Subject: RE: Planning Consultation on: BN/81/20/DOC

Engineers Comments Regarding Surface Water Drainage

Application No: BN/81/20/DOC
Registered: 23rd July 2020
Site Address: Swallowfield Eastergate Lane Eastergate PO20 3SJ
Description of Works: Approval of details reserved by condition imposed under ref BN/121/19/PL relating to Condition Nos 3 - surface water drainage, 4 - Construction Management Plan, 5 - materials & finishes, 6 - hard & soft landscaping, 7 - drainage scheme, 8 - storage of waste and 13 - renewable energy.

Revision:			
address Swallowfield, Eastergate Lane Eastergate, PO20 3SJ			
project Proposed construction of detached chalet bungalow			
title Proposed Surface Drainage			
scale 1:500 @A4	date May 2020	dwg no 2019.257DRA	revision

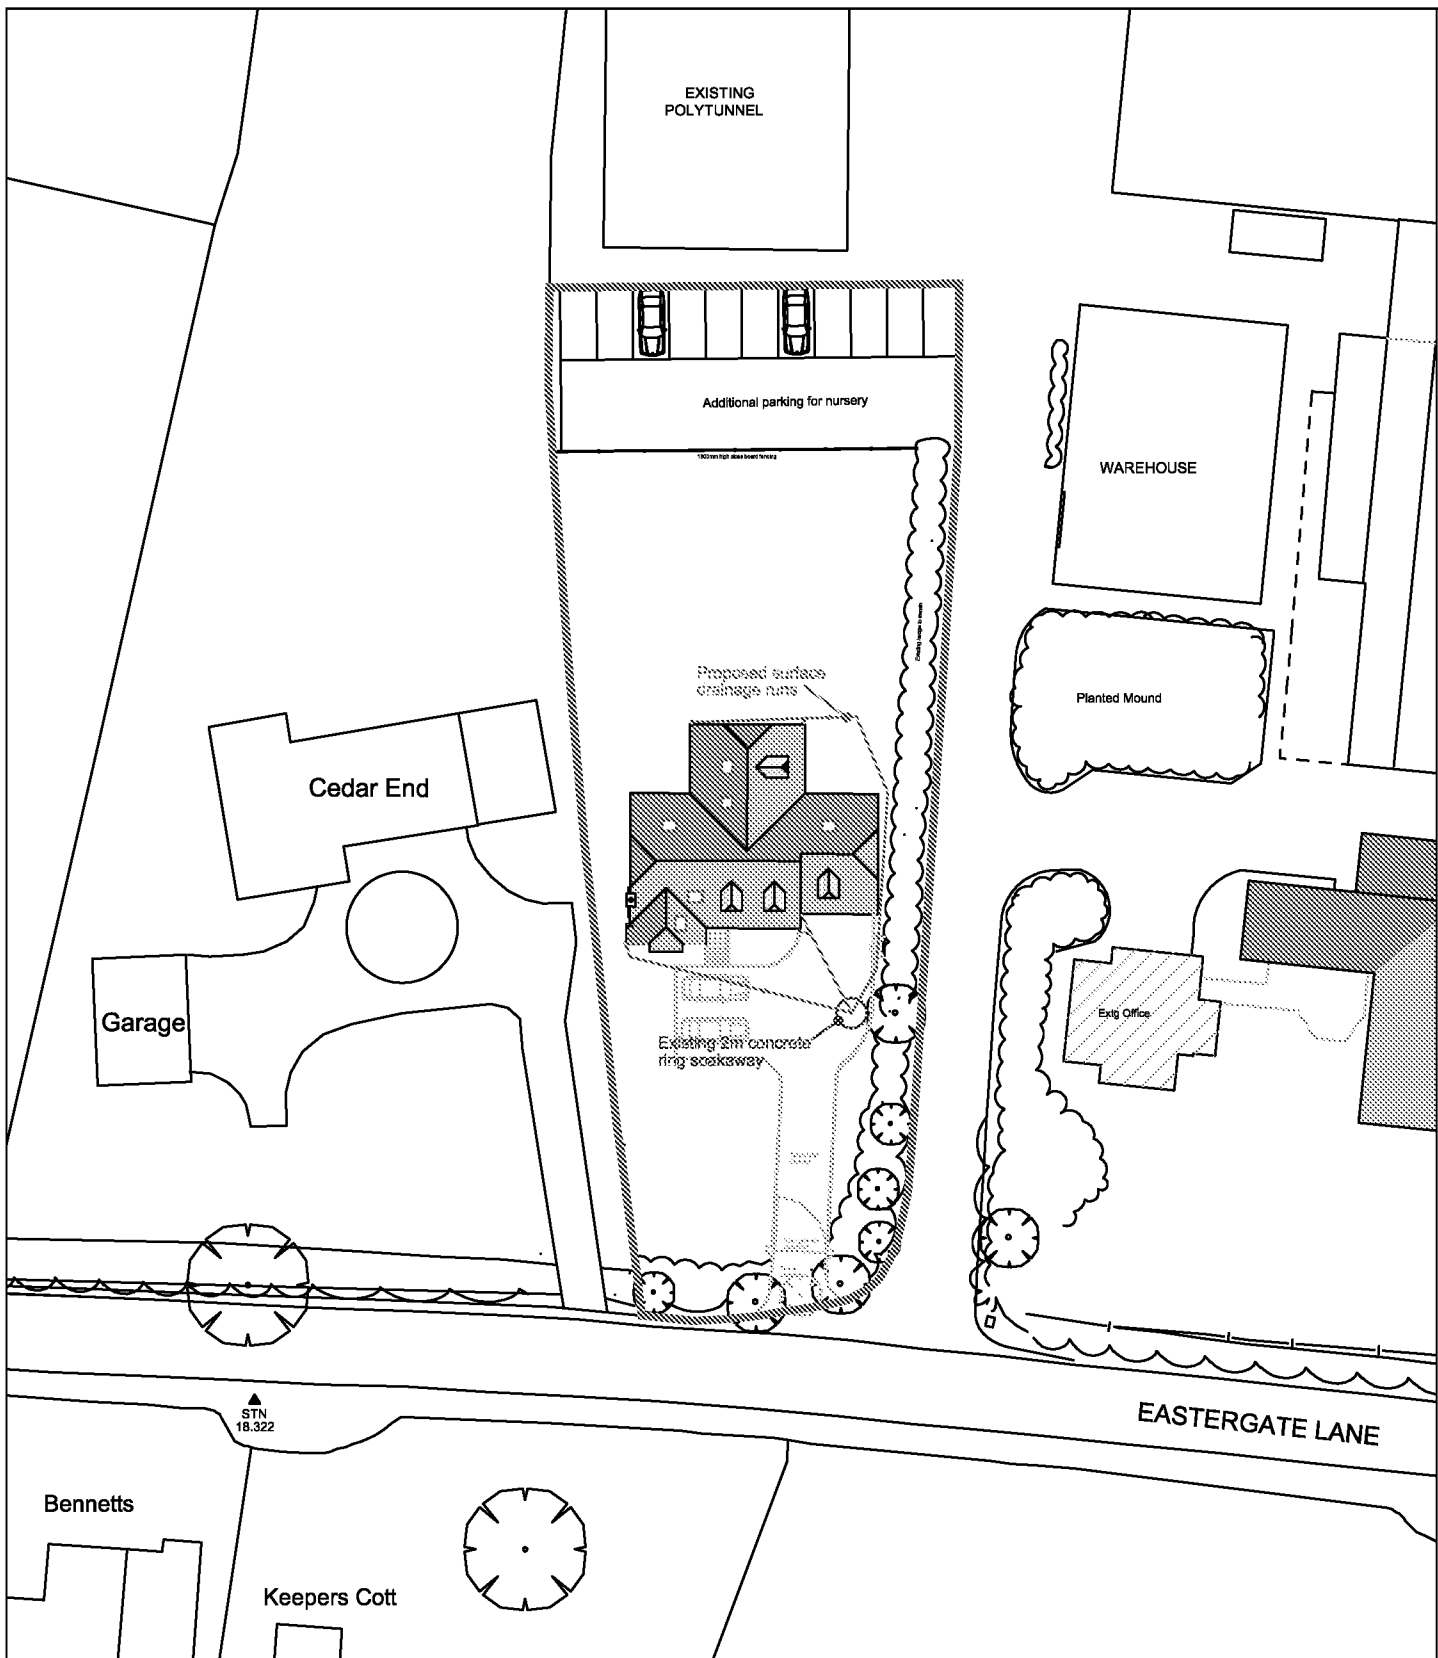
The information supplied is insufficient to recommend discharge of condition 3 and 7 on application BN/121/19/PL. Whilst the principle of utilising the existing soakaway may be feasible, calculations will need to be provided to show that it meets our requirements, and a detailed drainage layout and construction details will also be required. These calculations will rely upon winter infiltration testing (and groundwater monitoring) as per condition 3.

We provide a [Surface Water Drainage Checklist](#) which applicants are guided to in an informative on their decision notice, this makes clear the level of detail required in terms of testing, calculations, the drainage layout and the construction detail drawings. Given that we are currently months away from the winter period, unless the applicant is able to provide winter results from a previous year, I would recommend that the application is refused and a new submission is made in early 2021.
